CITY OF ALBUQUERQUE

RE: **McDonalds – Menaul and San Pedro**
5900 Menaul Blvd NE
Site Plan for Building Permit
(Non-stamped) Plan Date: 8/9/18 (File: H18D070)

Based upon the information provided in your submittal received 8/10/18, the Grading and Drainage Plan is approved for Site Plan for Building Permit.

SDP-3

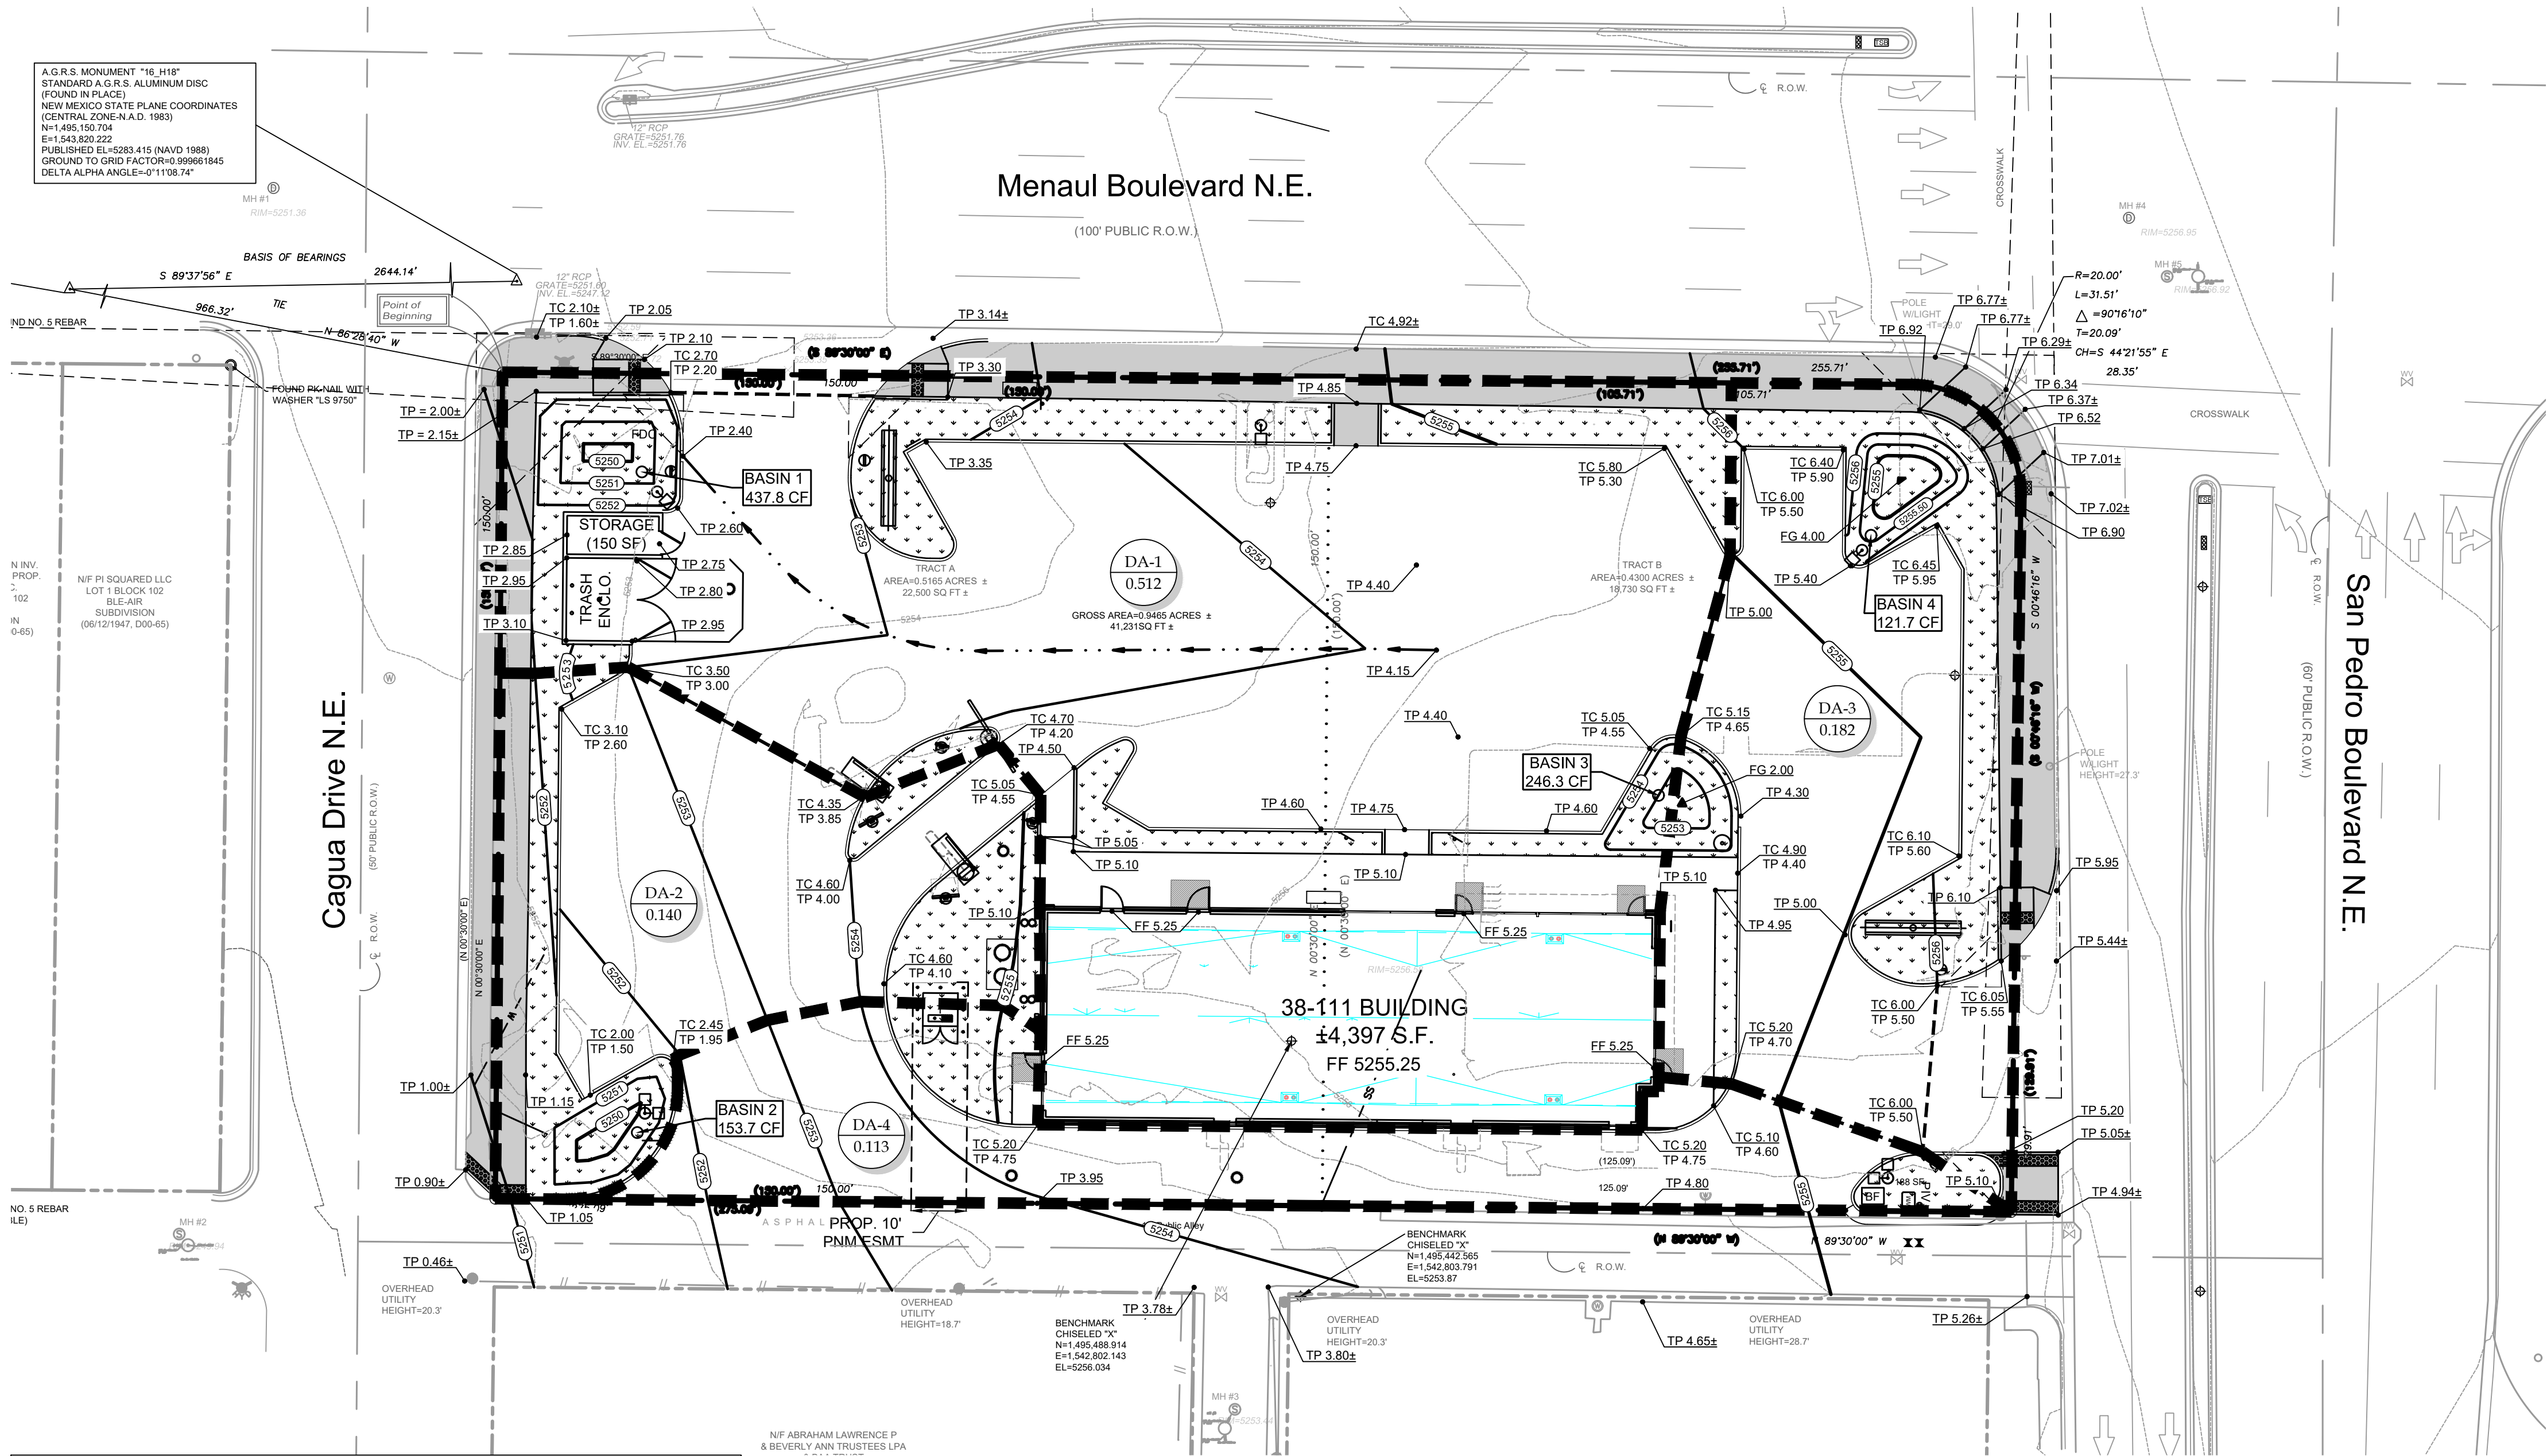
1. The resubmittal fee (\$300) for SPBP needs to be received. There will also be a resubmittal fee for the Building Permit grading plan (\$300).
2. Grading and repaving of the alley needs to be correctly shown; Alleys have an inverted crown (Std dwg 2411) and the contours and proposed spot elevations should reflect this. Provide existing tie-in elevations on the south side of the alley and provide flow capacity calculations for the new alley section.

3. Provide capacity calculations for the sidewalk culvert. Demonstrate 100-yr flow capacity for its contributing drainage area and provide InvertIn and InvertOut elevations.

4. Remove all "Conceptual" markings.
5. Payment of the Fee in Lieu (Amount = 133CF x \$8/CF, per sheet SDP-3) for the required first flush volume must be made.

6. Waterblocks, 12" high from top of pavement on the driveway to bottom of gutter along the road, need to be incorporated at the San Pedro entrance.
7. This work will require an Erosion and Sediment Control Plan submitted to the storm water quality engineer (Curtis Cherne, PE, ccherne@cabq.gov) before Building Permit Approval.
